WEST SUSSEX COUNTY COUNCIL CONSULTATION

TO:	Arun District Council FAO: Anita Gardner
FROM:	Steven Shaw County Highways, WSCC
DATE:	24/07/2018
LOCATION:	Land To The Rear of Bairds Farm Shop, Crookthorn Lane, Climping, West Sussex
SUBJECT:	CM/16/18/PL Development of a 64-bed Specialist Dementia Care Centre together with access, parking & landscaping (Use Class C2). This application is a Departure from the Development Plan & affects the setting of a Listed Building.
DATE OF SITE VISIT:	July 2018
RECOMMENDATION:	☐ Advice ☐ Objection ☐ Modification ☐ No Objection ☒ More Information ☐ Refusal
S106 CONTRIBUTION TOTAL:	See below for breakdown.

DRAWING TITLE
Highway Improvements

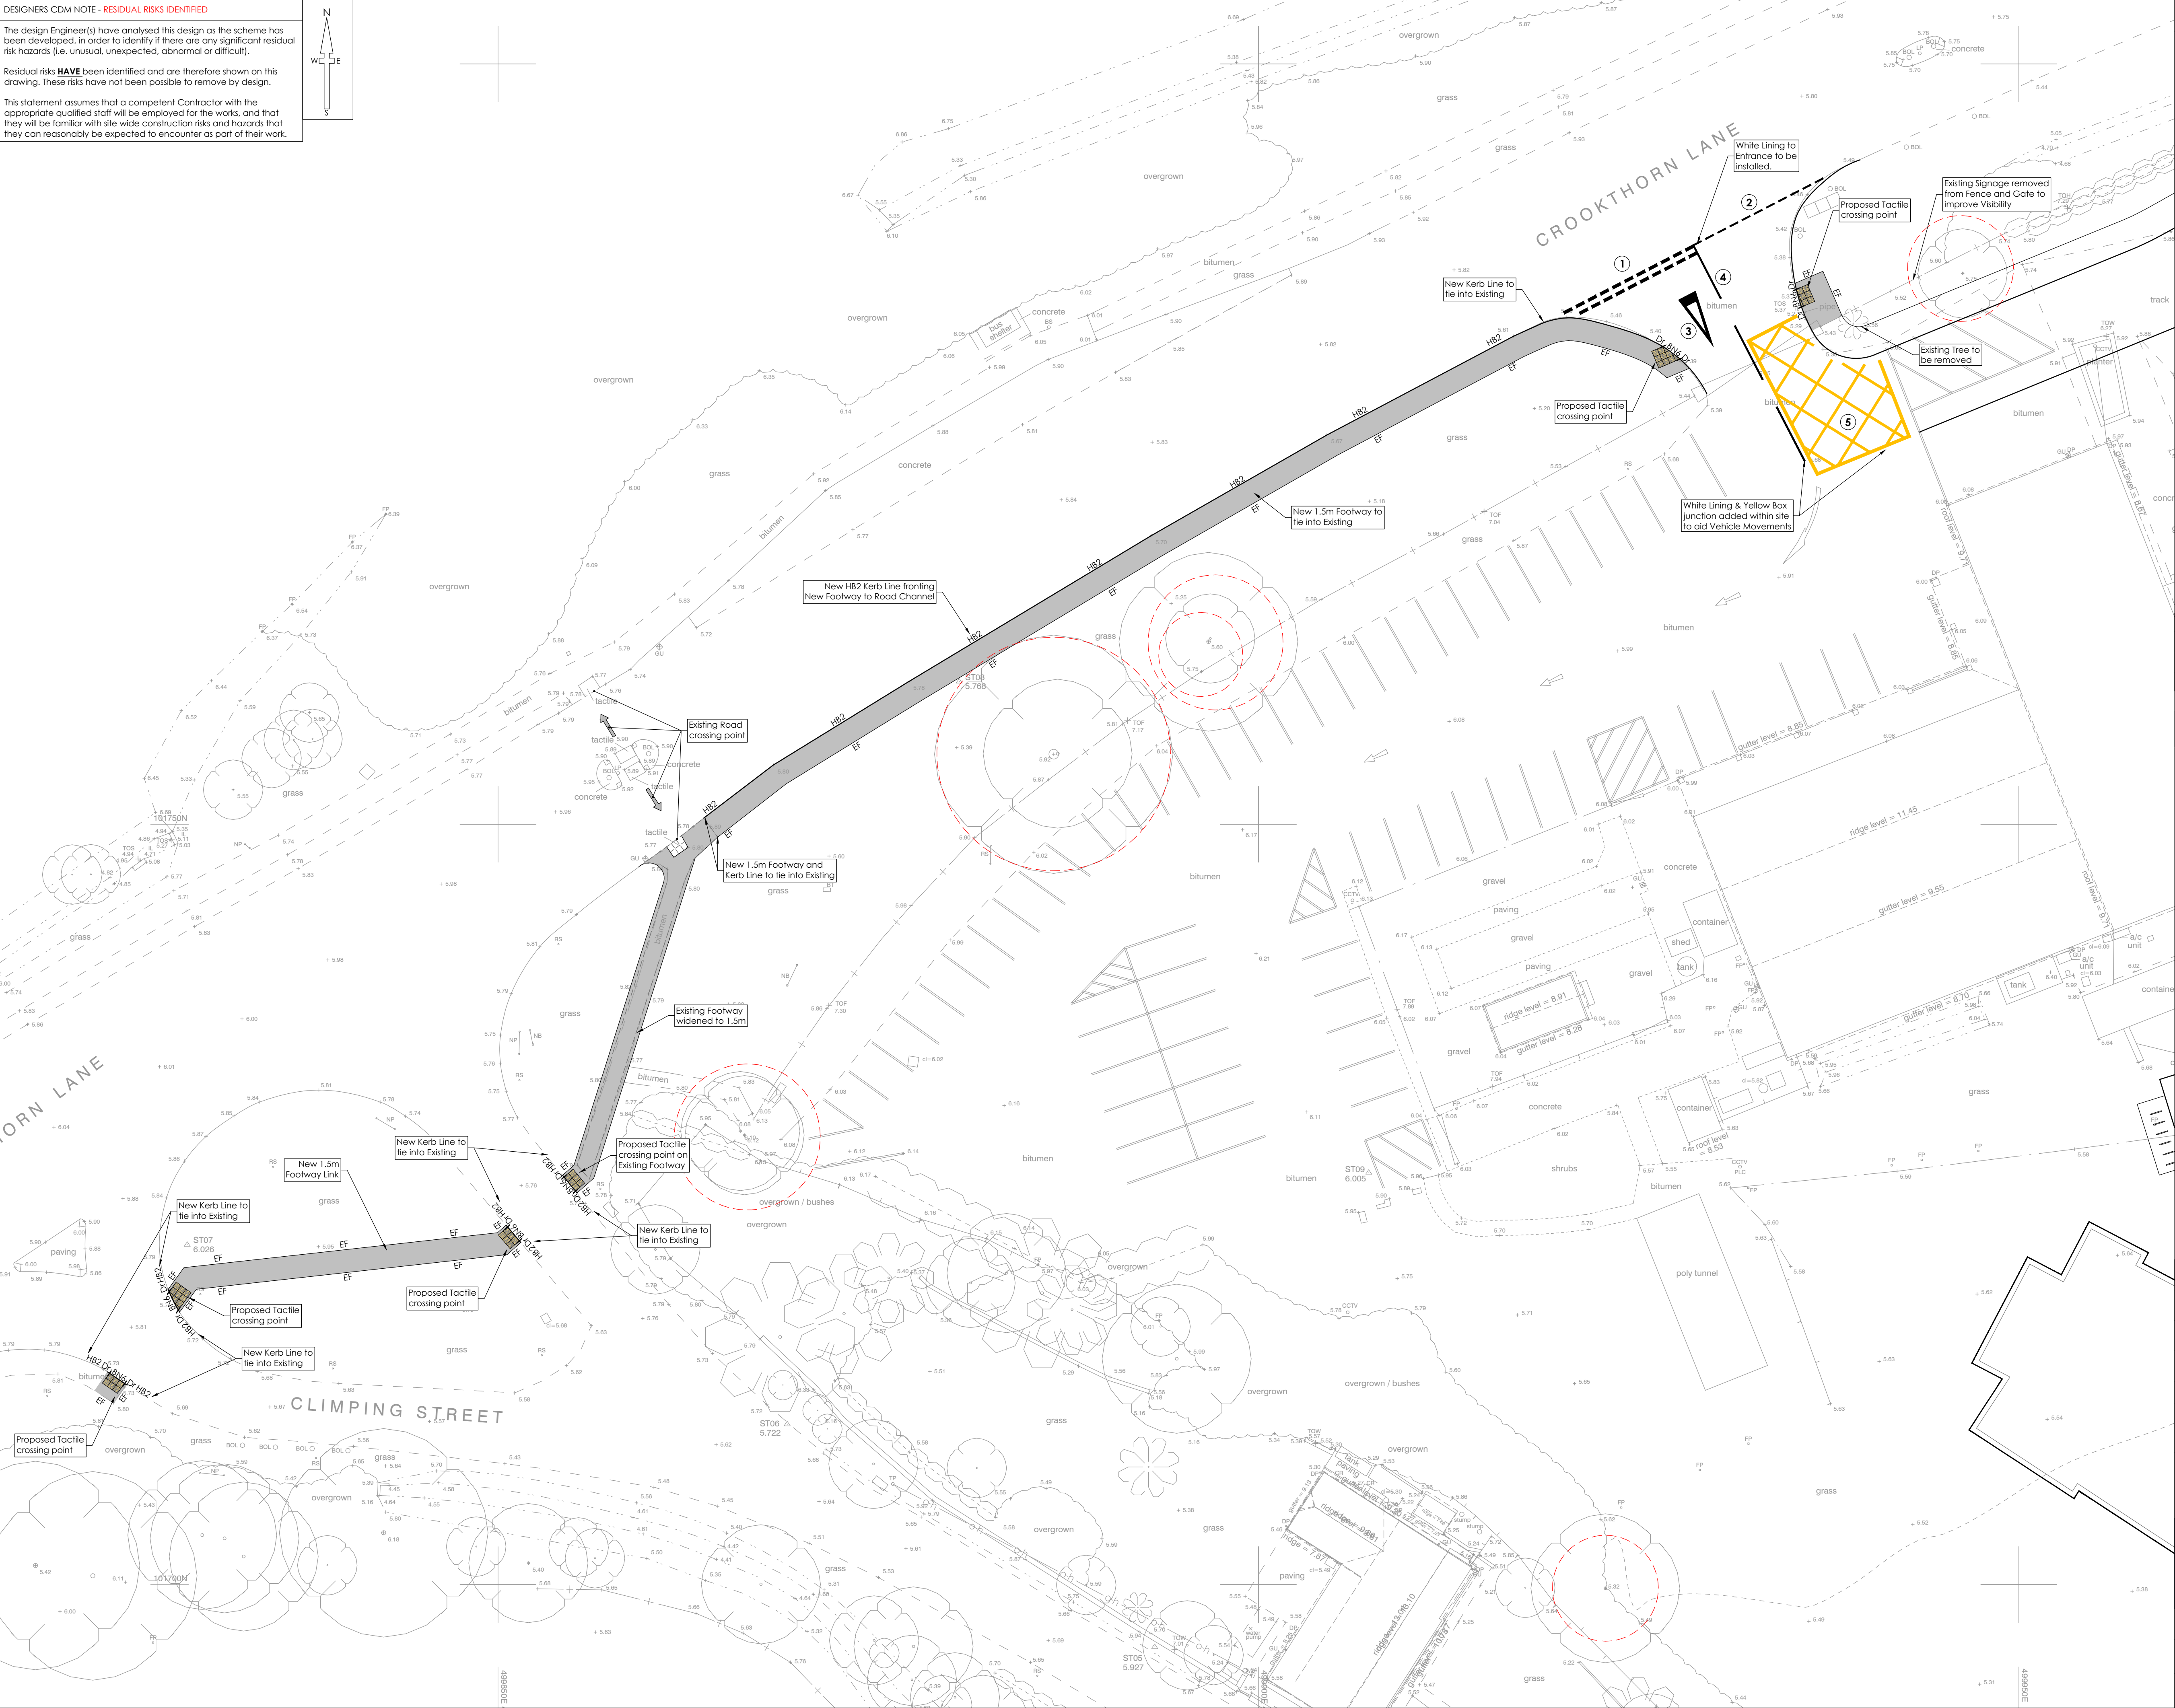
The main pedestrian entrance to the care home is from within the car park. This is accessed along a segregated 2m wide footpath and is considered to provide a safe means of access into the site. As part of the proposed development the applicant is providing a new 1.5m wide footpath along the site frontage which extends westwards from the site access to the westbound bus stop on the southern side of the A259. Dropped kerbs and tactile paving are also provided at appropriate crossing points.

No part of the development shall be first occupied until the highway improvement scheme to provide give way and centre line markings at the site access and a minimum 1.5m footway from the site access to the western side of Climping Street with appropriate dropped kerbs and tactile paving has been constructed in accordance with the approved plan.
